## DRB CASE ACTION LOG (Preliminary/Final Plat)

DRB Application No.: 11DRB-70041

Project # 1008683

Project Name: Sunshine Terrace Addition

ALPHA PROFESSIONAL SURVEYING, INC.
P.O. BOX 46316, RIO RANCHO, NEW MEXICO 87174
GARY@ALPHAPROFSURVEYING.COM 505-892-1076
DRAWN BY: GEG FILE NO: 11-004

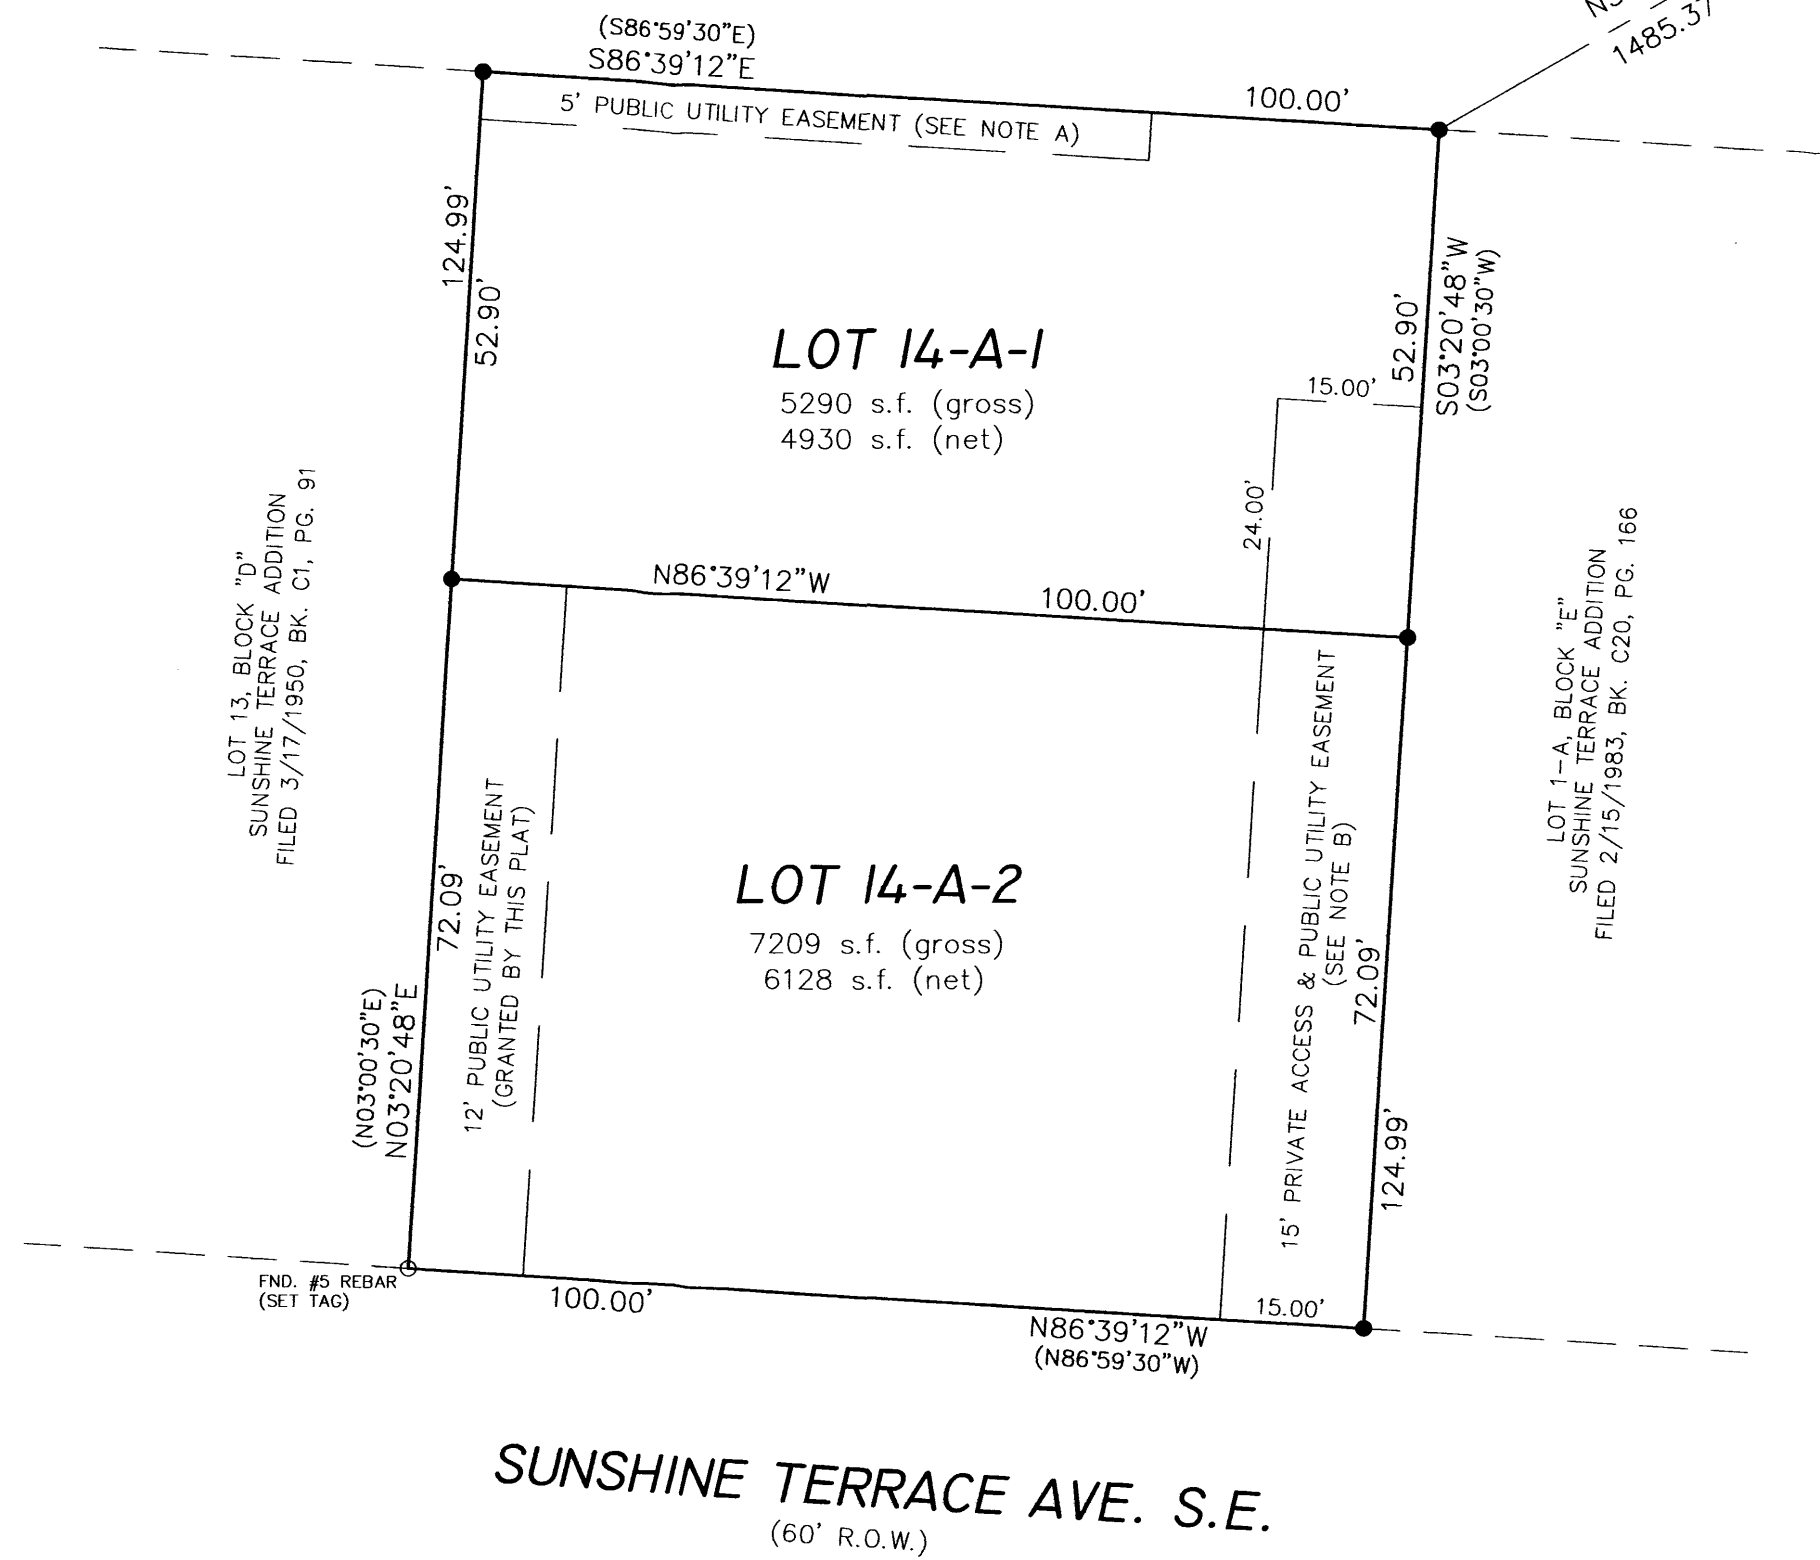
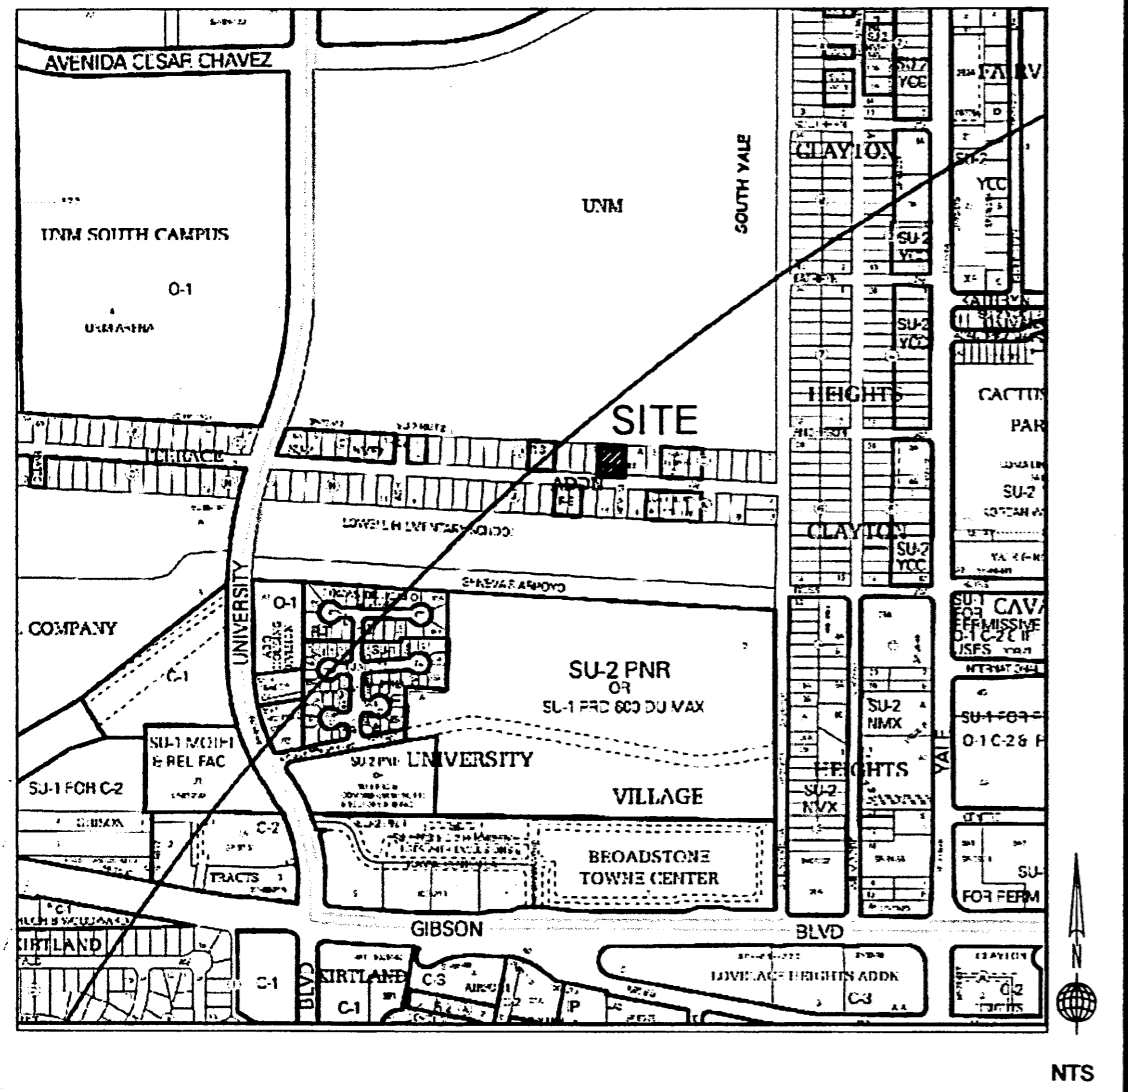
ABCWUA: - new service

*reference variances  
OK blanket drainage E' meet for  
marsh lot*

ALPHA PROFESSIONAL SURVEYING agent(s) for RICHARD K WOLFSON request(s) the above action(s) for all or a portion of Lot(s) 14-A, Block(s) D, **SUNSHINE TERRACE ADDITION** zoned R-1, located on SUNCHINE TERRACE AVE BETWEEN UNIVERSITY AND BUENA VISTA containing approximately .2869 acre(s). (L-15) **THE PRELIMINARY/FINAL PLAT WAS APPROVED WITH FINAL SIGN OFF DELEGATED TO ABCWUA FOR NEW SERVICE AND TO PLANNING TO REFERENCE VARIANCE AND BLANKET DRAINAGE EASMENT FOR NORHT LOT.**
